Subject: RE: Planning Consultation on: BN/93/21/PL

Engineers Comments Regarding Surface Water Drainage

Application No: BN/93/21/PL

Site Address: Land off Highground Lane Barnham PO22 0BJ

Figure 3 Environment Agency's Flood Map

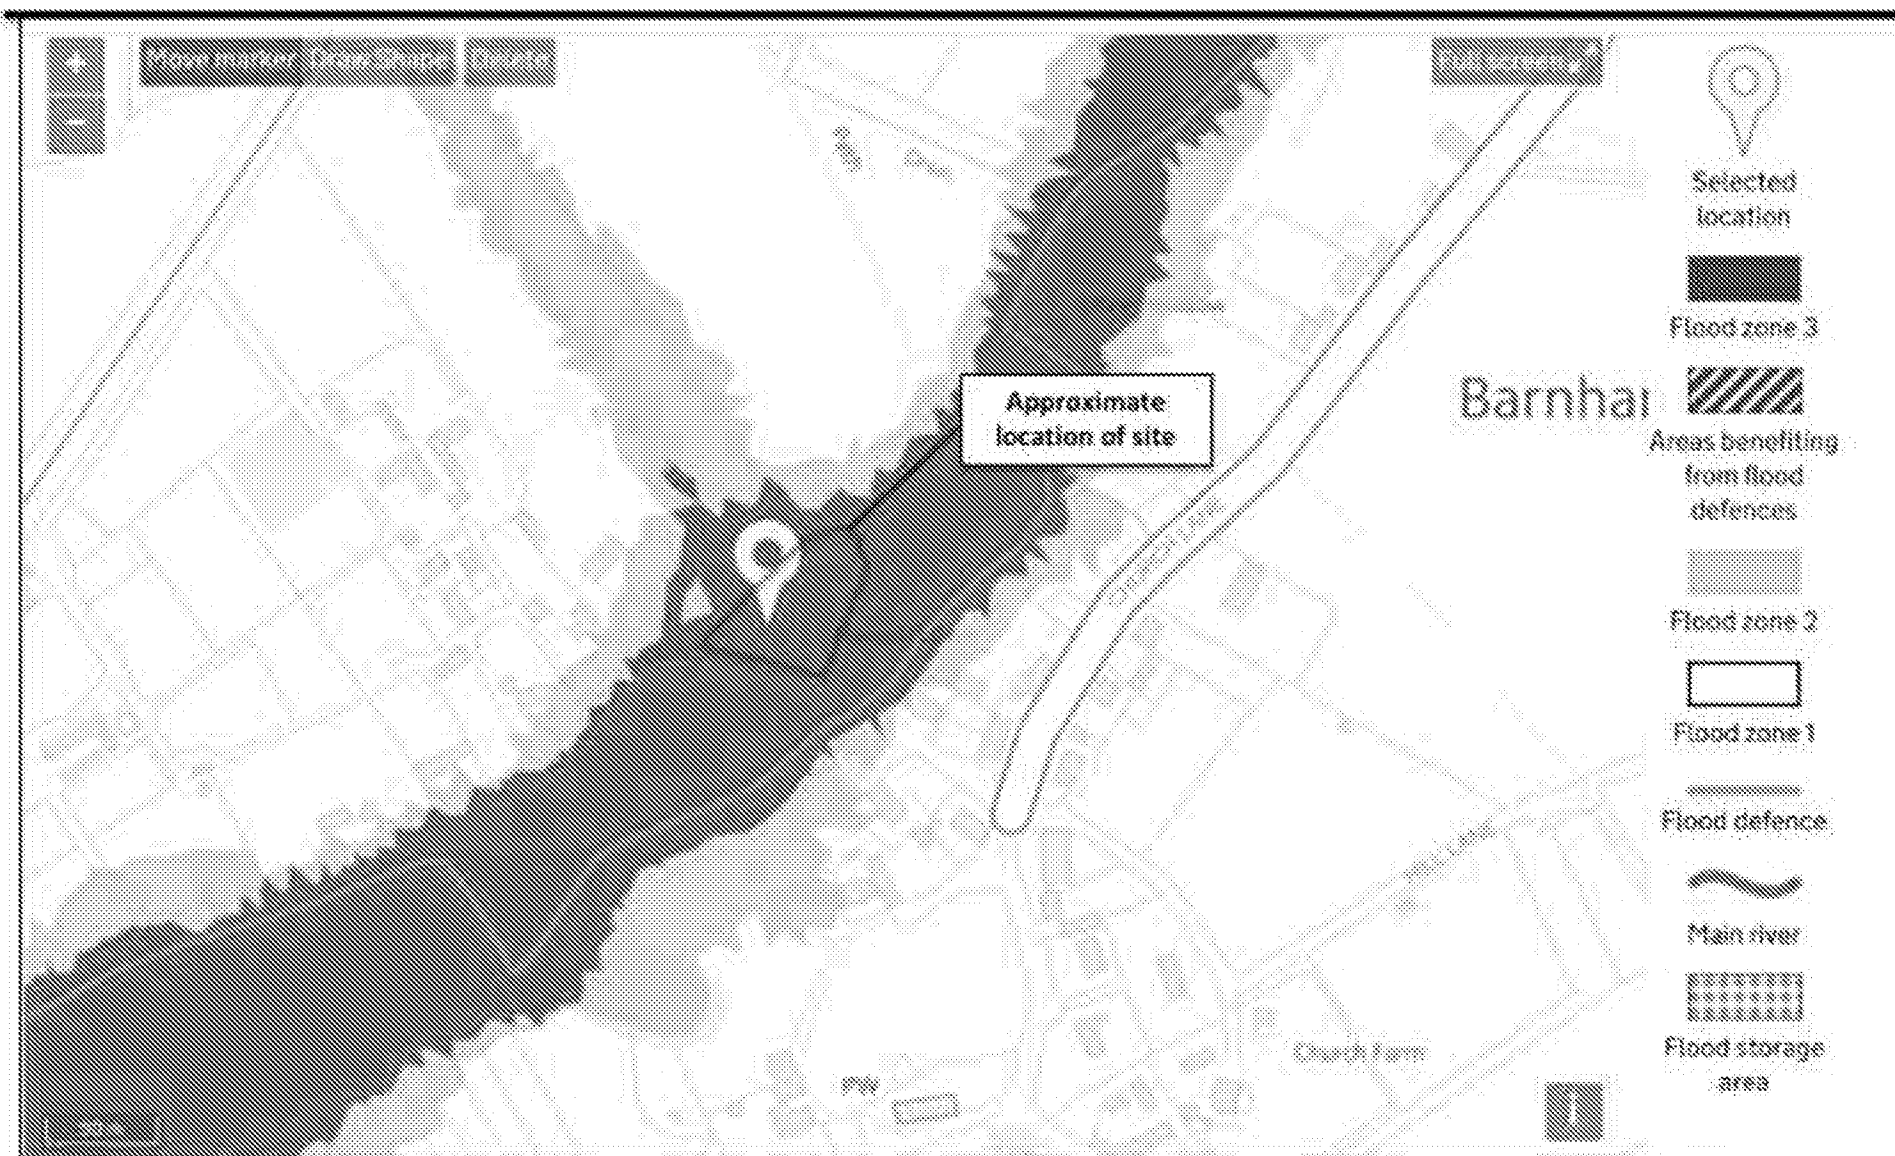
The FRA for this application appears to have significant omissions and errors. Part of the application site (where part of the proposed dwelling is proposed) appears to be classified as functional flood plain Flood Zone 3b ([Arun SFRA mapping](#), sheet 22 of 48).

This is land “where water has to flow or be stored in times of flood. This zone is generally defined as the land which would flood with an annual probability of 1 in 20 (5% AEP) or greater in any year” (this is the case for the Arun District). As shown in the applicant’s FRA “Only the water-compatible uses and the essential infrastructure listed in Table 2 that has to be there should be permitted.” As the development is for “More Vulnerable” use as a dwelling house Table 3 Flood Risk Vulnerability and Flood Zone ‘compatibility’ shows that **development should not be permitted**.

Furthermore the FRA does not appear to have evidenced an appropriate sequential test (as required for all sites in Flood Zone 3) to show that there are no reasonably available alternative sites for the development to be located.

In order to overcome my objection the FRA would need to be updated to account for the omissions and discrepancies described above. Furthermore, I would expect all surface water drainage design to be agreed prior to determination, with appropriate winter groundwater monitoring and infiltration testing. The surface water drainage design would have to show that flooding would not be increased on-site or off-site for the lifetime of the development with appropriate allowances made for climate change and urban creep.

Figure 5 Environment Agency's Surface Water Flood Risk Map

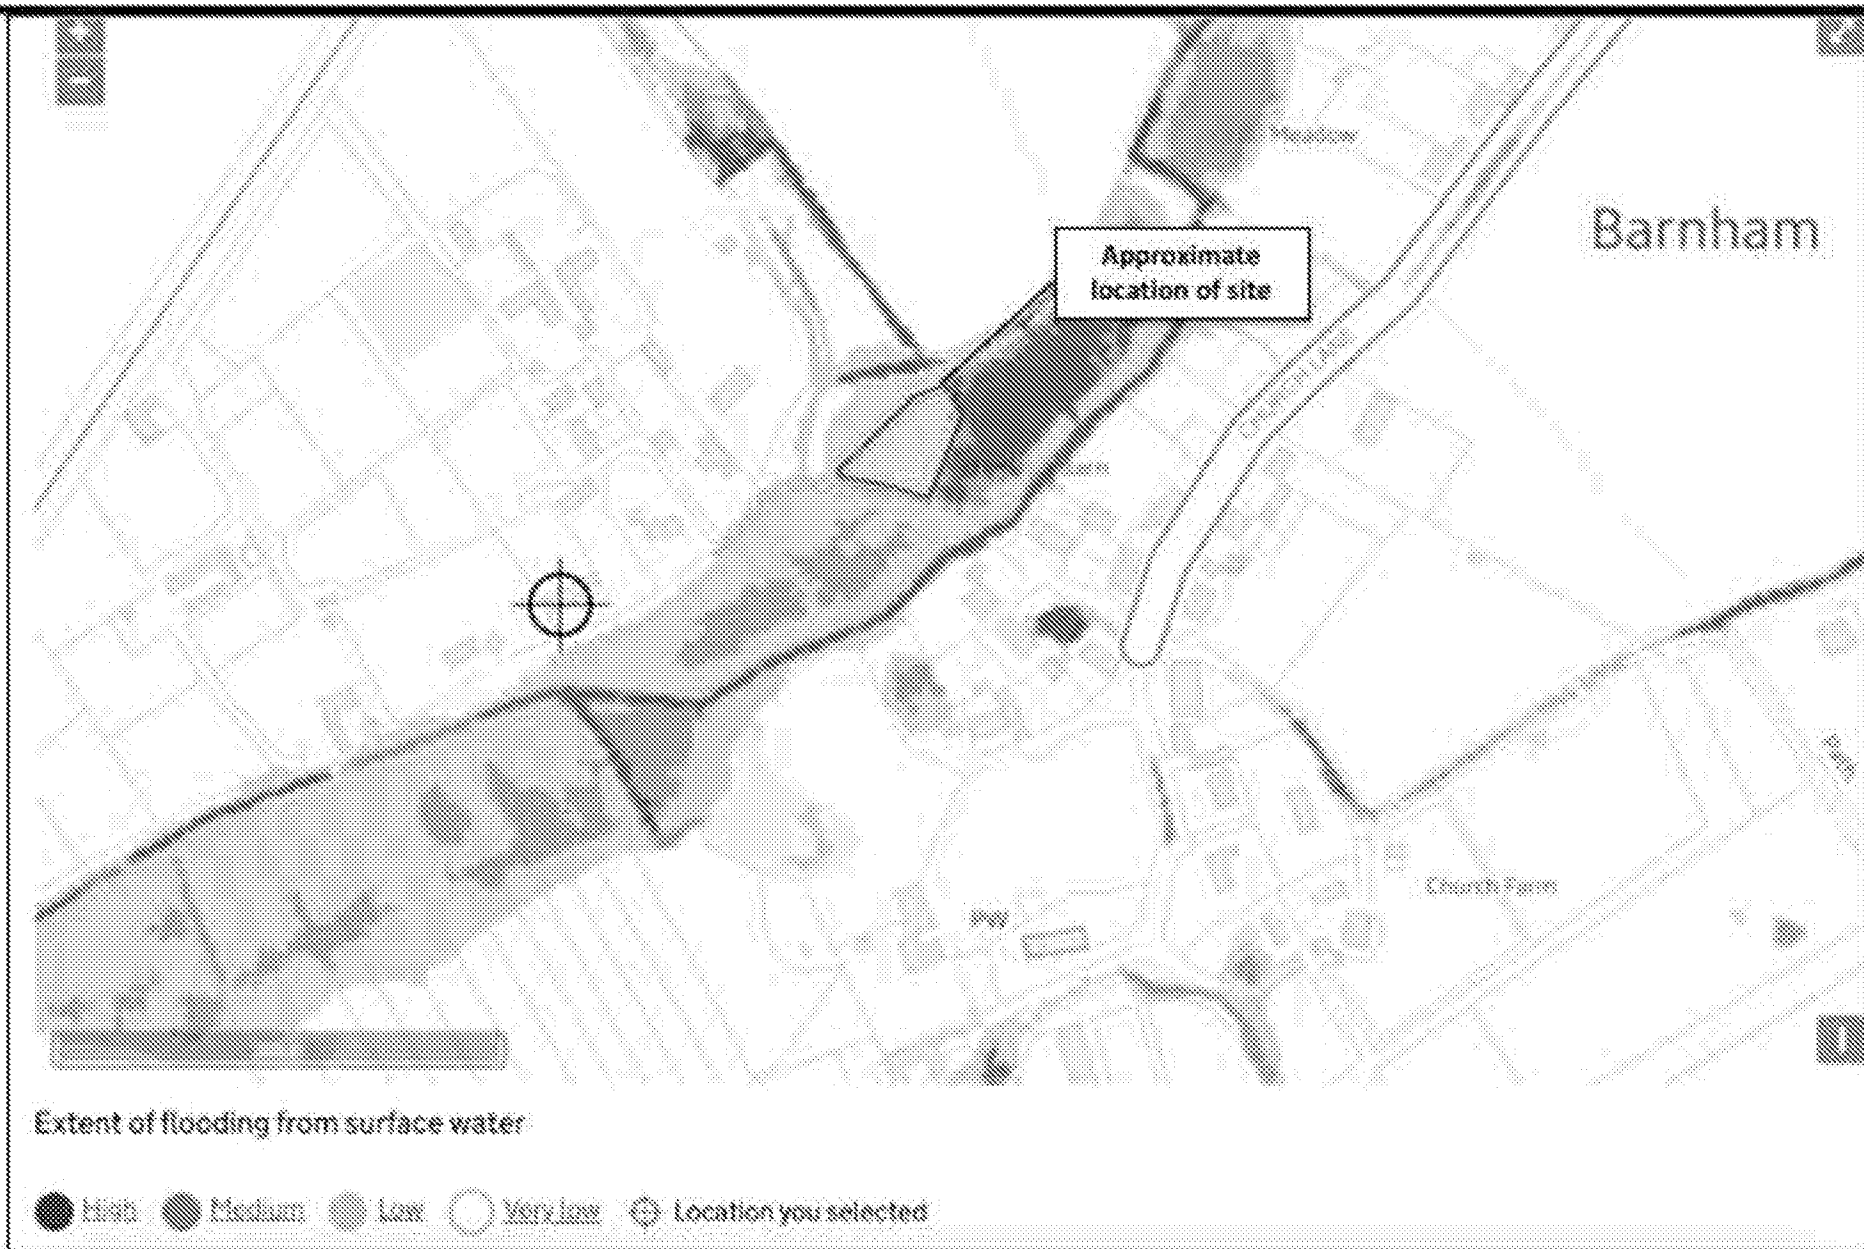
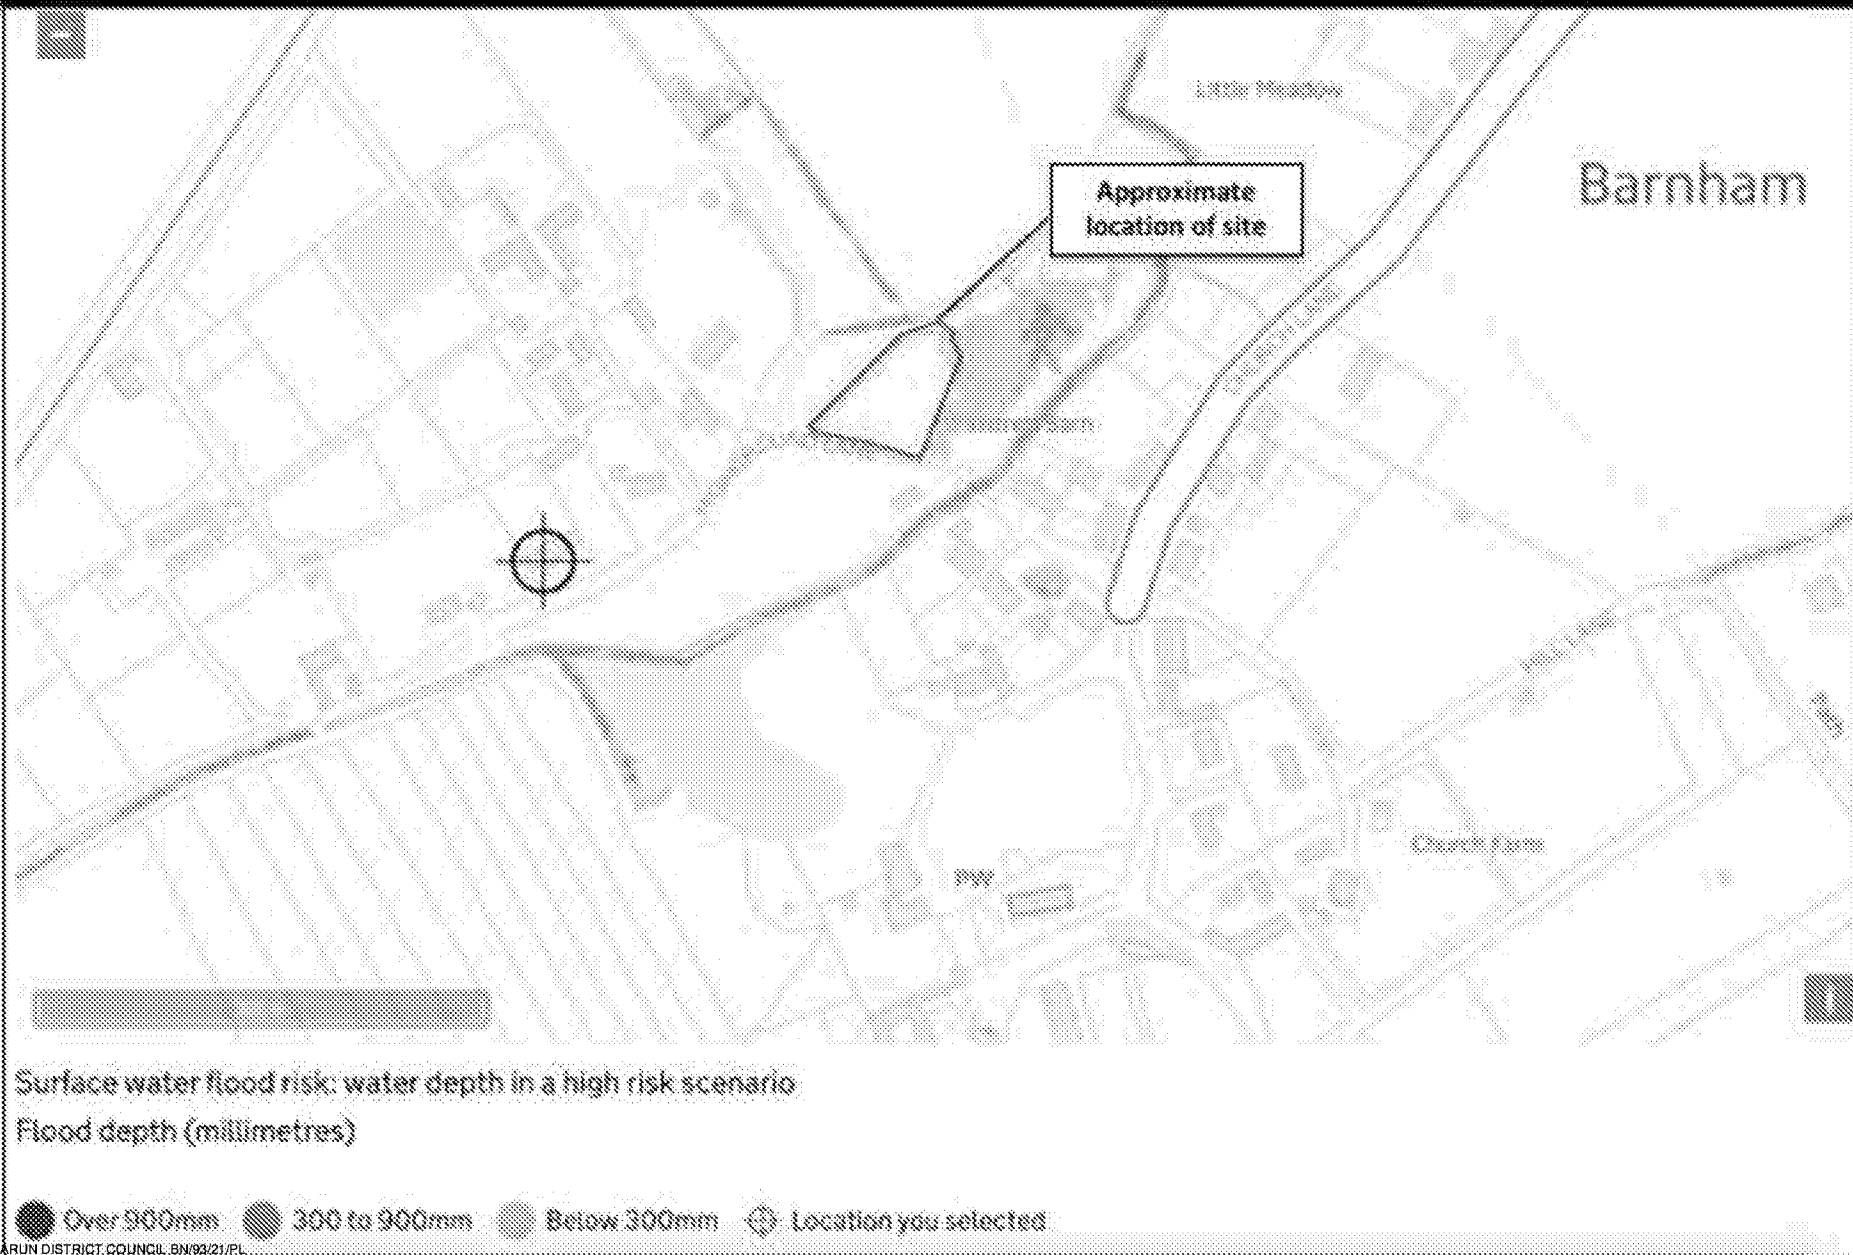
The FRA states that “overall risk of surface water flooding to the site varies from ‘low’ to ‘high’ with the maximum flood depth less than 300mm”. EA Mapping shows that maximum flood depth (for 1 in 1000 year event) is up to 600mm, for a 1 in 100 year event the maximum flood depth is 300mm. The FRA also states that there are no records of historic flooding at the site. However, our mapping (supplied by the EA) clearly shows the site within the Historic Flood Map for Arun District. The FRA also states that the previous land owner was “not aware of any flooding issues at the site”. This is a direct contradiction of public representations (of objection) to the application at least one of which offering evidence. It is suggested that the Planning Officer obtain any evidence of flooding from these members of the public should they be minded to refuse the application (as it could be used as evidence in the case of appeal).
